## Report of the Head of Development Management and Building Control

**Address:** 15 ROKER PARK AVENUE ICKENHAM

**Development:** Erection of a first floor extension to side.

LBH Ref Nos: 41735/APP/2023/3496

Drawing Number: 2373-PL-101      Scales: 1:50 @ A3      Rev. No. —

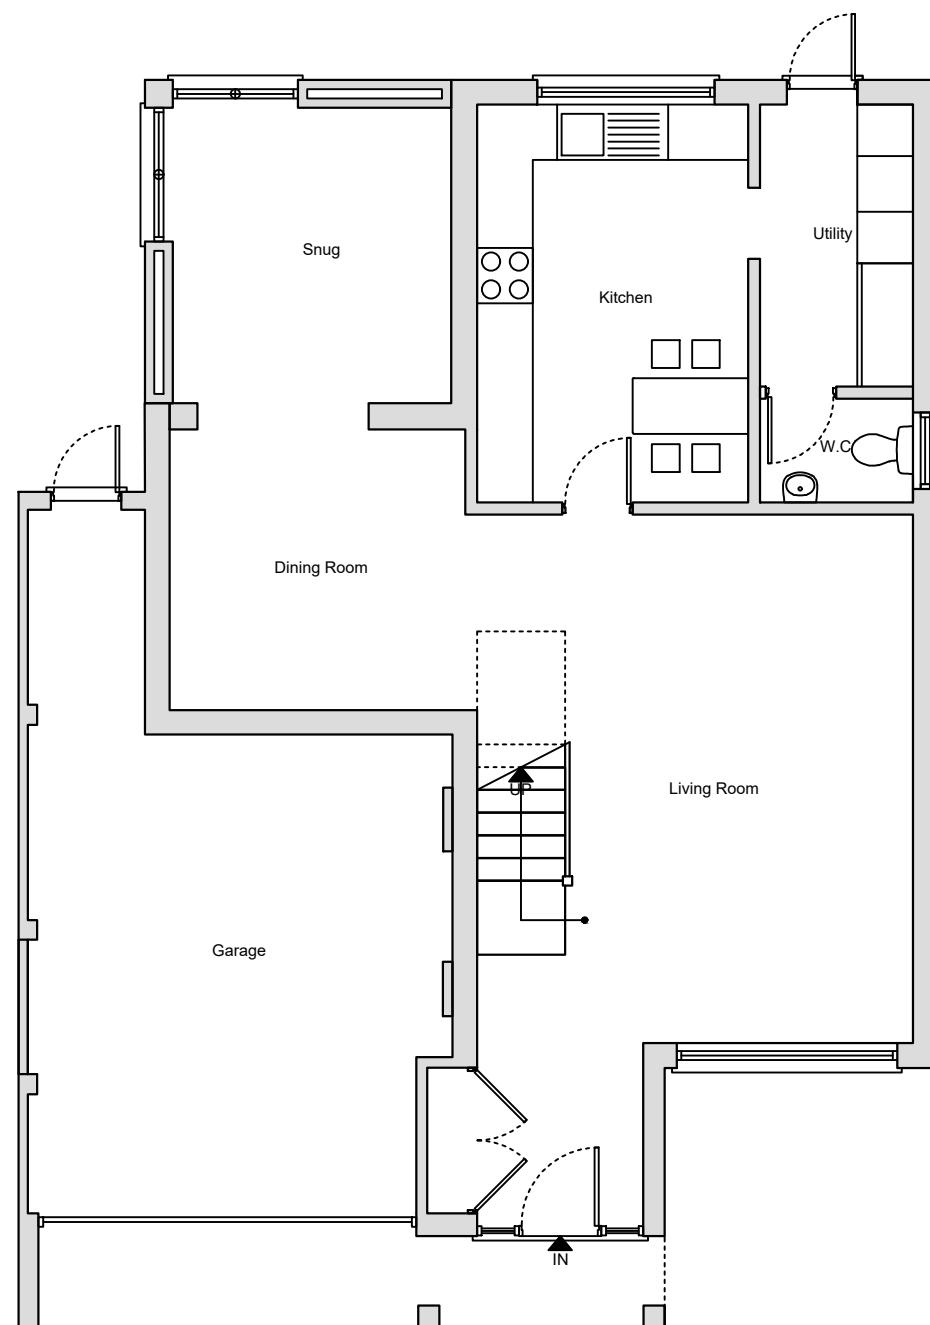
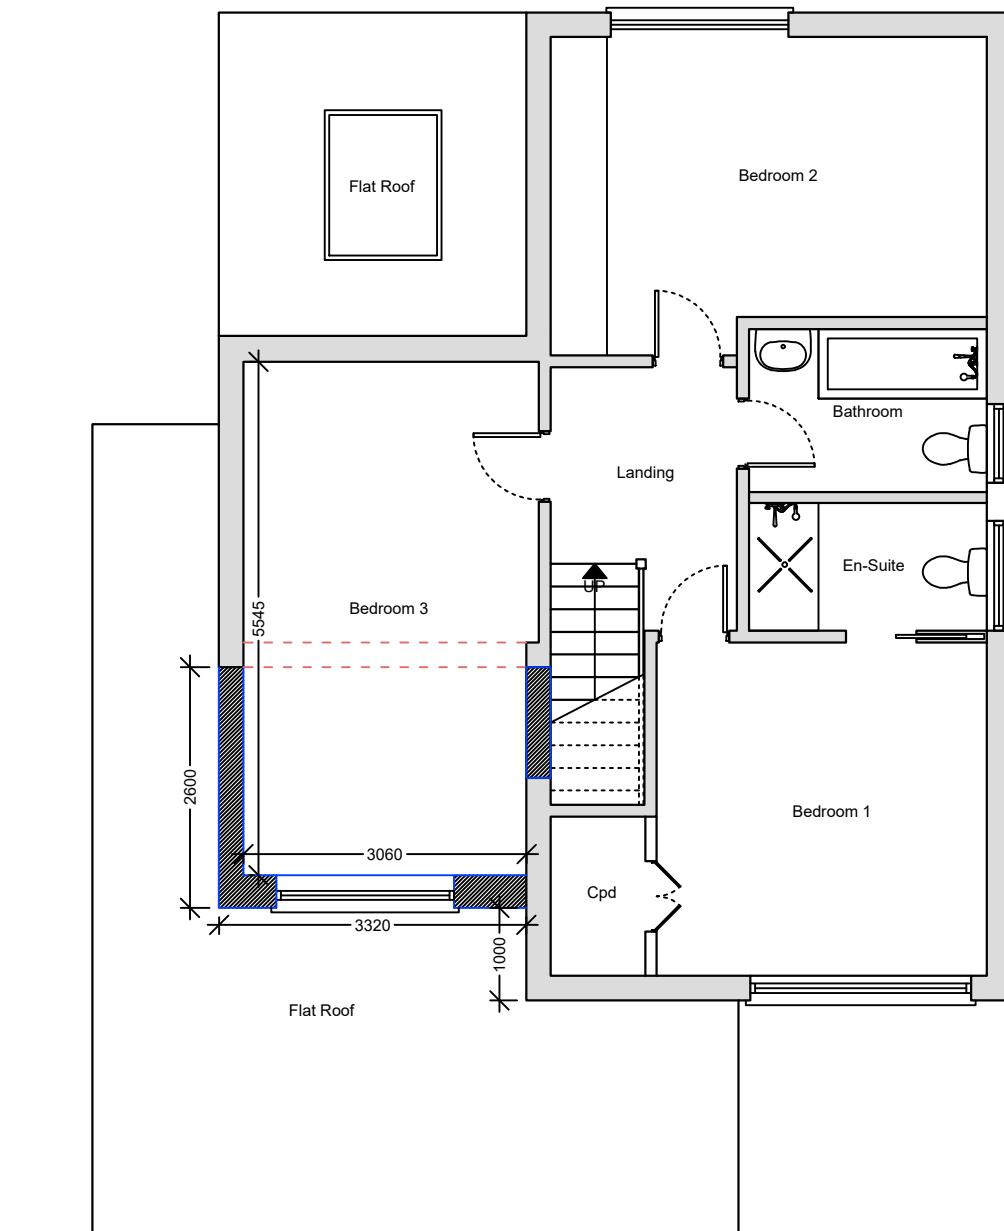
The application proposes a first floor side extension which would essentially infill the first floor gap towards the front, the proposal would measure a depth of 2.6m, a length of 3.3m and follows a similar ridge line as the host dwelling. In comparison with the previously refused scheme, the proposal is now set back 1m from the first floor line as opposed to the 0.5m set back proposed under planning application reference: 41735/APP/2023/140. In assessing the scheme at Appeal, the Inspector stated that although the extension would have the same ridgeline as the host, the original building's staggered form, which is so typical of Roker Park Avenue, would be much diminished. In the streetscene, the resultant building would thus be markedly at odds with the prevailing style of houses in the road.

Despite the increase in the proposed set back from the first floor building line, it remains considered that the proposed first floor extension, and markedly the loss in the characteristic set back would fail

to harmonise with the original architectural composition of the host dwelling and the surrounding properties, and would result in a visually incongruous addition that would affect the symmetry of the development along Roker Park Avenue.

The proposed first floor side extension, by virtue of its size, scale, design and lack of a sufficient setback from the established front building line would result in an visually intrusive and visually incongruous addition that would fail to harmonise with the architectural composition of the original dwelling and the symmetry of existing development along Roker Park Avenue to the detriment of the visual amenities of the street scene and the character and appearance of the surrounding area. Therefore the proposal would be contrary to Policy BE1 of the Hillingdon Local Plan: Part One - Strategic Policies (2012) and Policies DMHB 11, DMHB 12 and DMHD 1 of the Hillingdon Local Plan: Part Two - Development Management Policies (2020).

Drawing Number:  
2373-PL-102

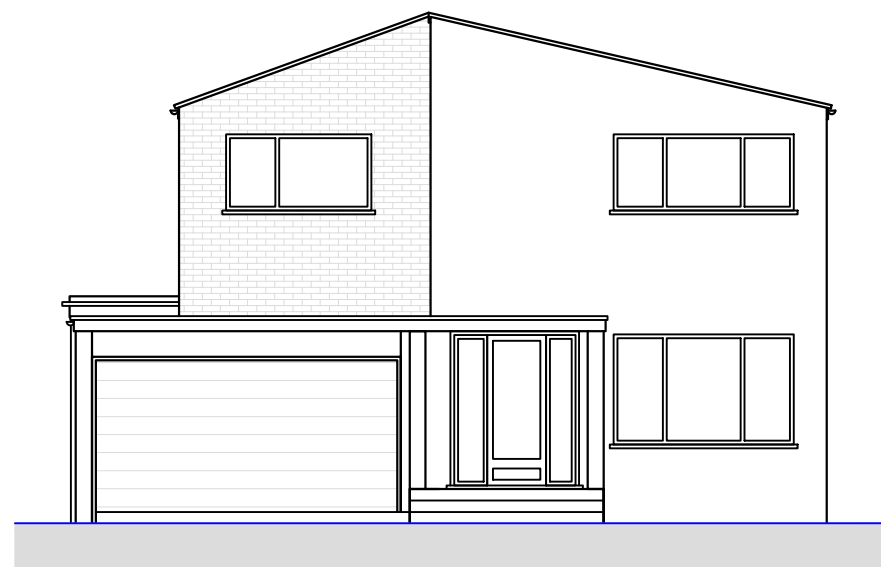
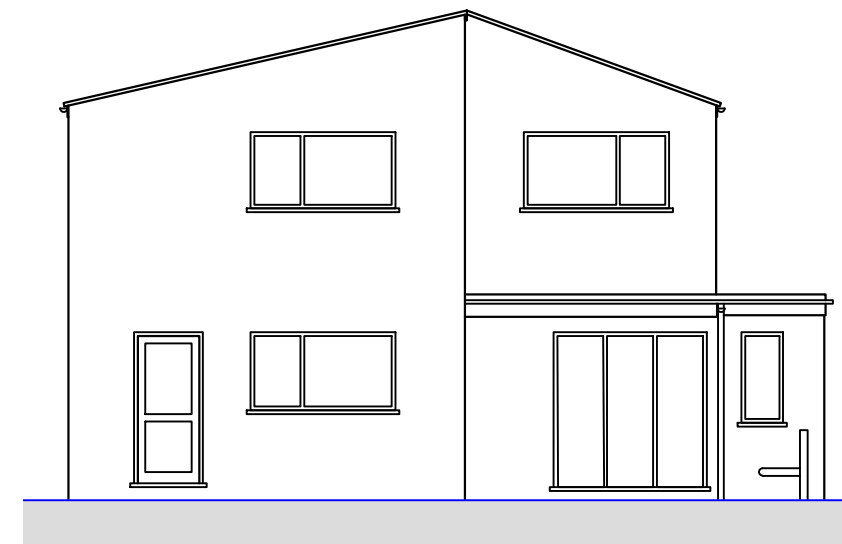
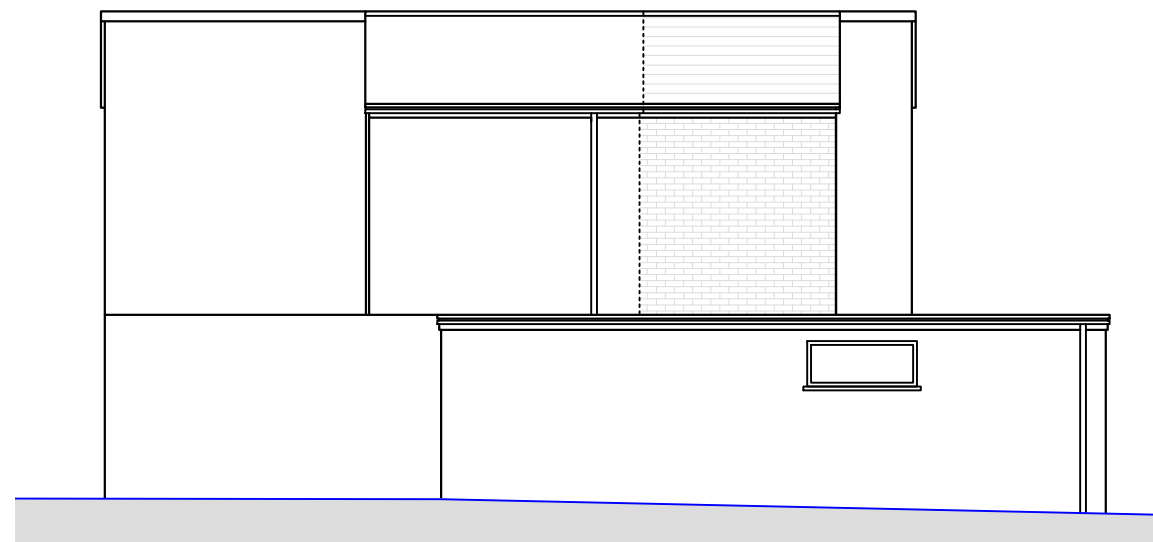
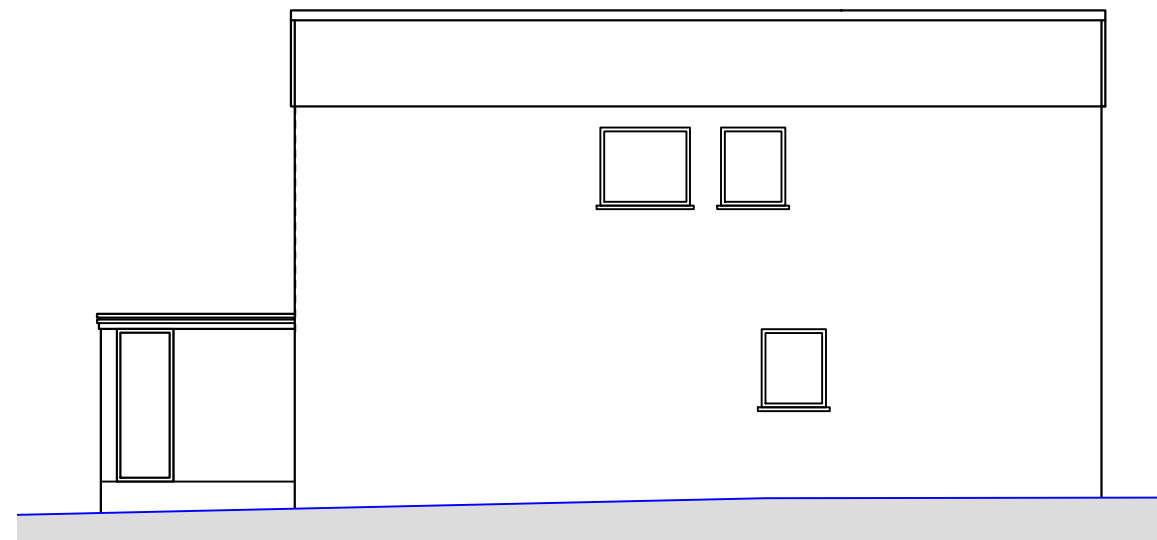
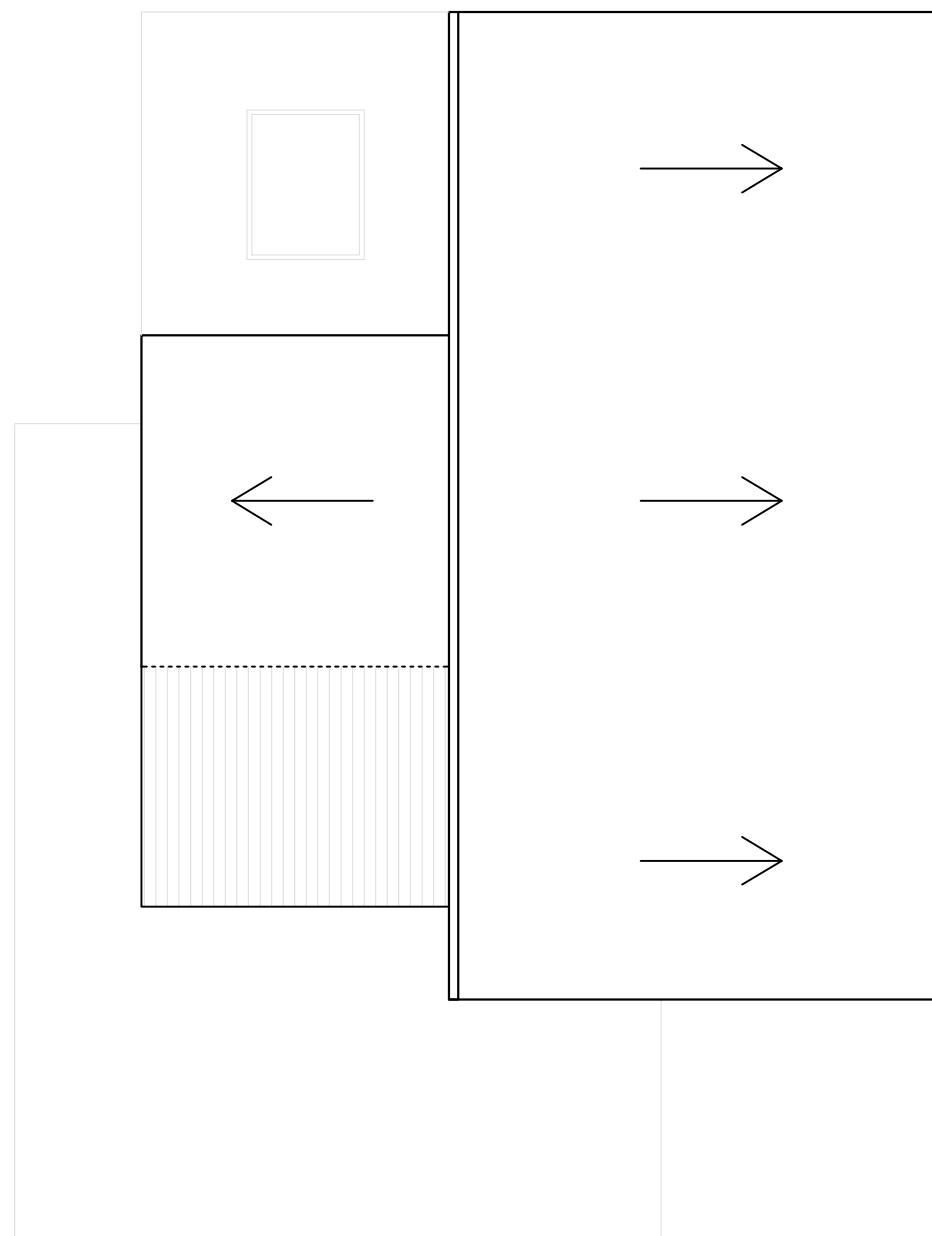
Taking the above into consideration, it is considered that the proposed development does not go far enough to mitigate the harm identified in the Officer Report and the Appeal Decision. Despite the use of matching materials, due to its form, style and siting, the scheme would significantly harm the character and appearance of the host property and surrounding area. It would thereby conflict with policies DMHB 11 and DHMB 12 of the Hillingdon Local Plan: Part 2 Development Management Policies (2020) and Policy BE1 of the Hillingdon Local Plan Part One: Strategic Policies (2012).
